MAYBERRY PHASE 1

THE NORTHEAST ONE-QUARTER (NE1/4) OF SECTION 15 AND IN THE NORTH ONE-HALF (N1/2) OF SECTION 14, ALL IN TOWNSHIP 14 SOUTH, RANGE 63 WEST OF THE 6th P.M., EL PASO COUNTY, COLORADO  
AN AMENDMENT TO ELLICOTT TOWN CENTER PHASE 1 PUD / PRELIMINARY PLAN

MAYBERRY PHASE 1  
AN AMENDMENT TO  
ELLICOTT TOWN CENTER  
PHASE 1 PUD  
DEVELOPMENT /  
PRELIMINARY PLAN

PUDSP-21-009

Lot Typical Type A
Less Than 55'-0"

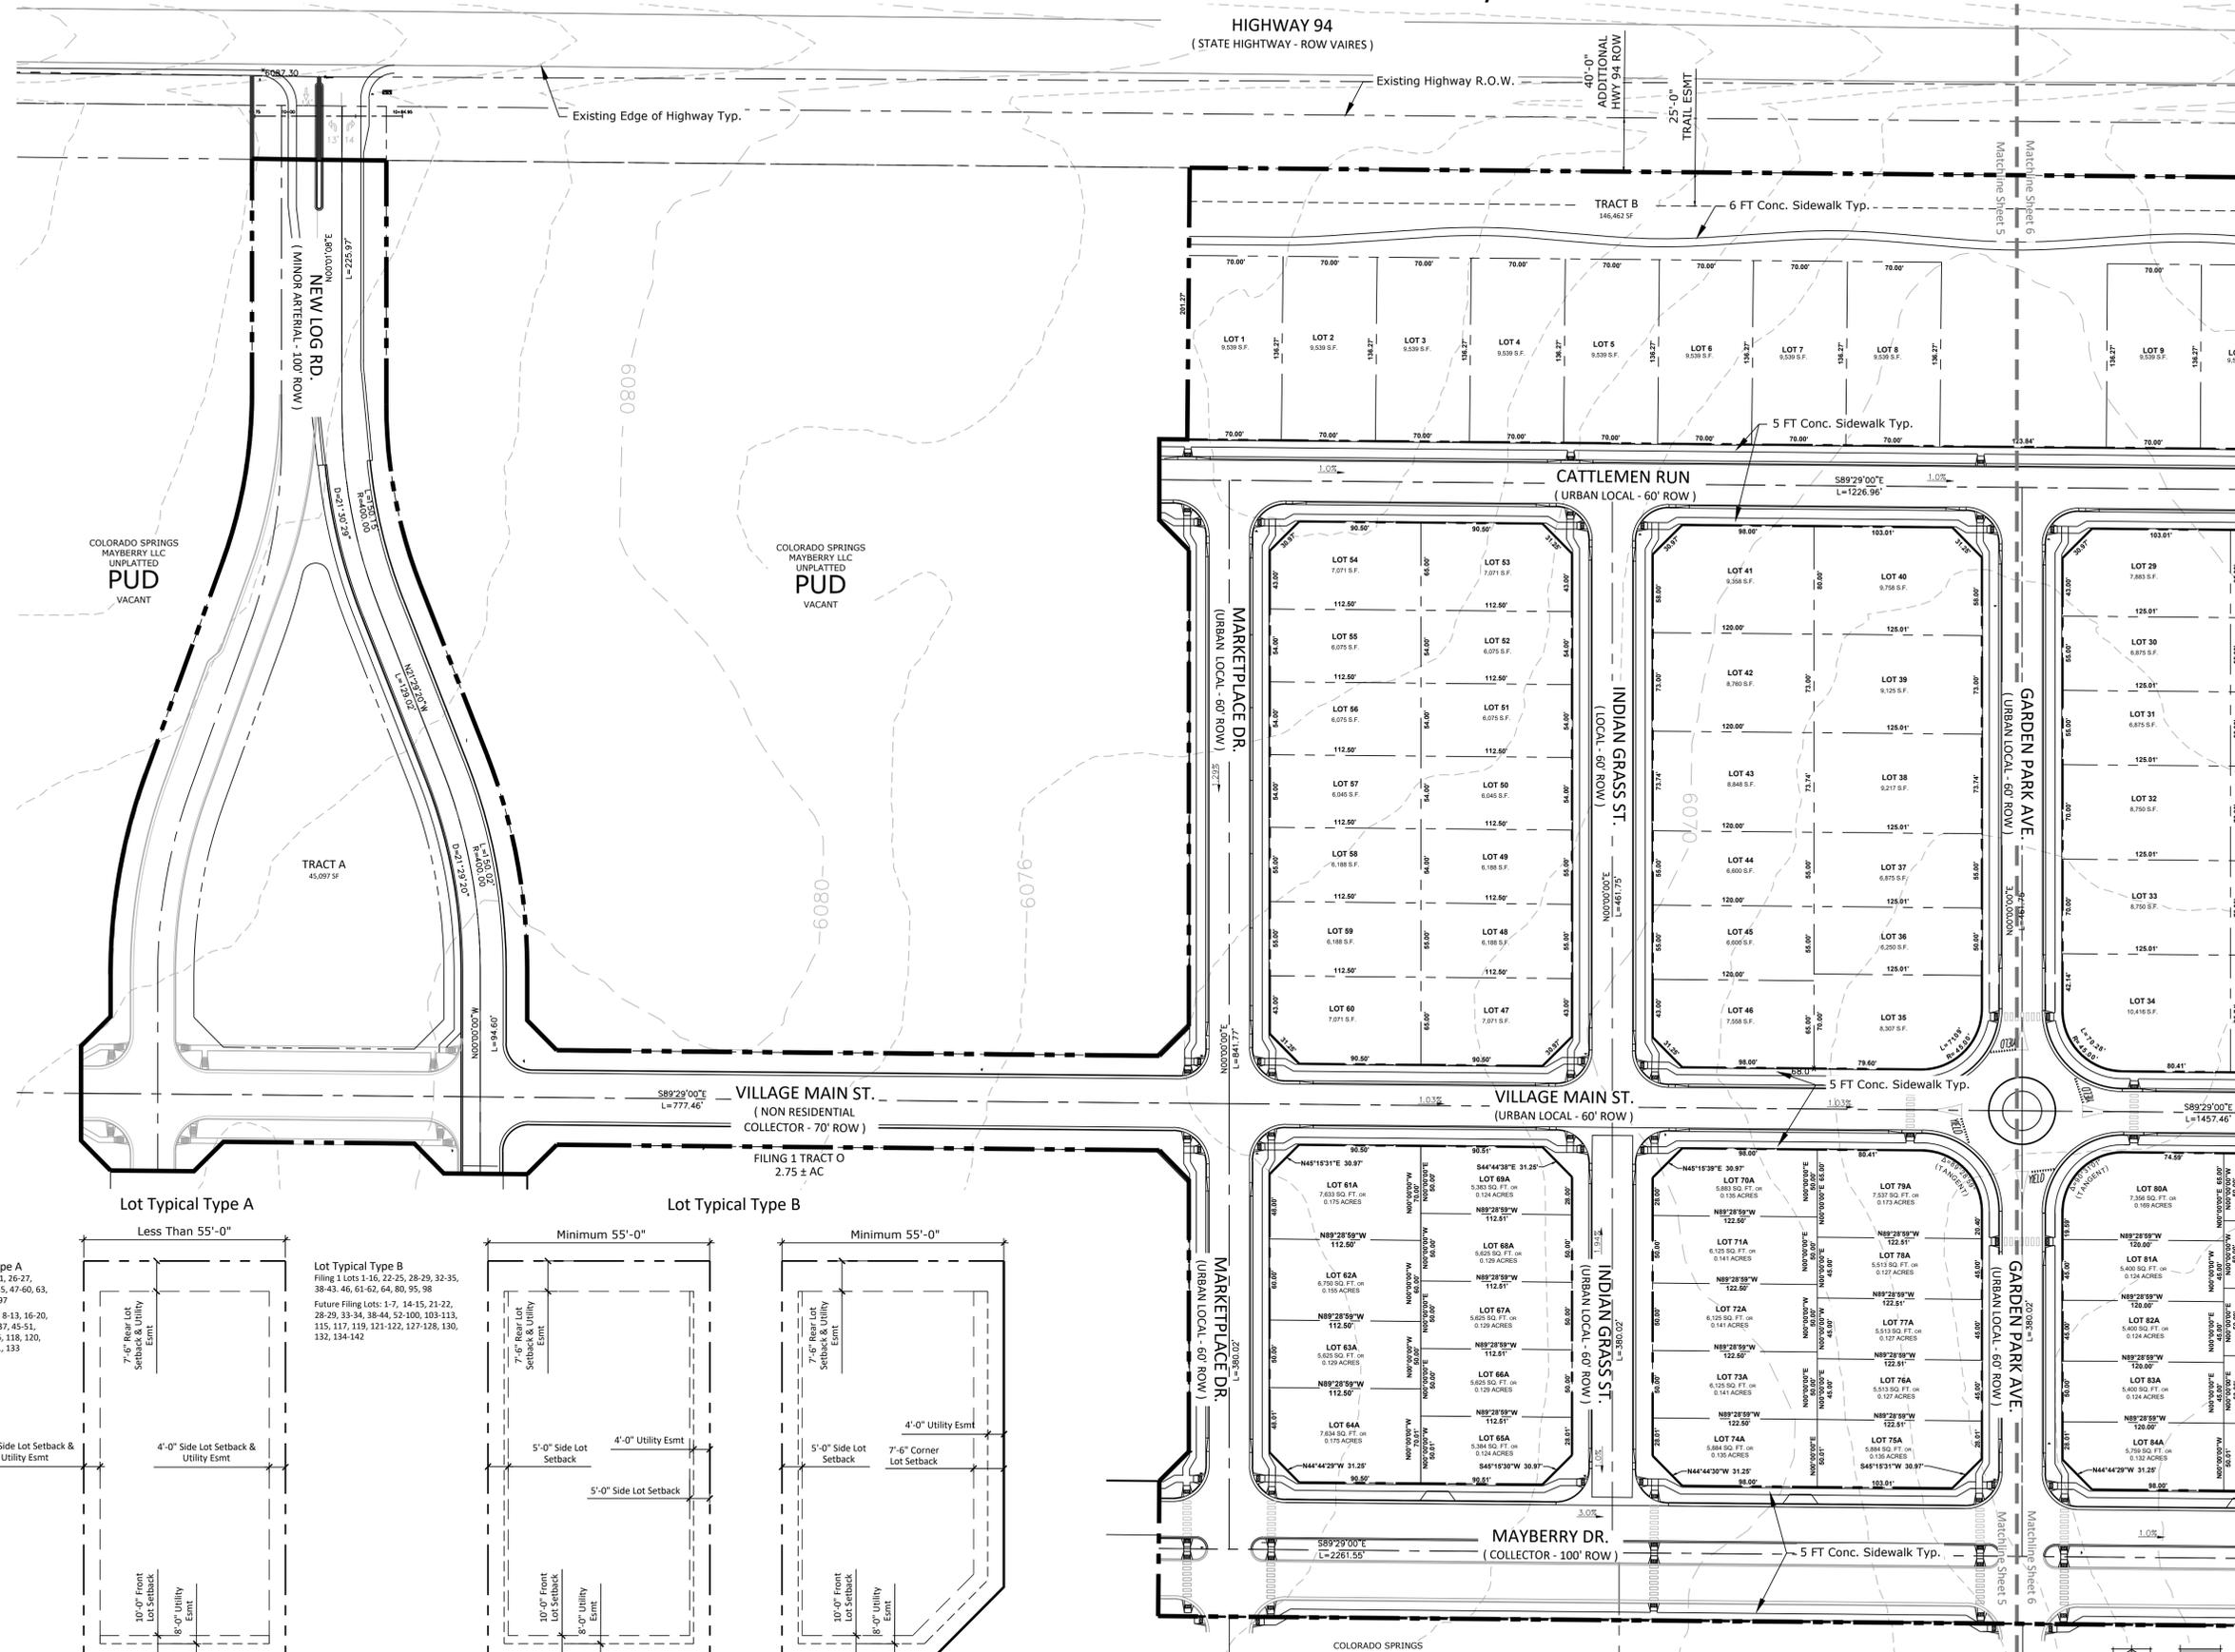
Please provide an exhibit in this plan that identifies which lots are Type A and Type B
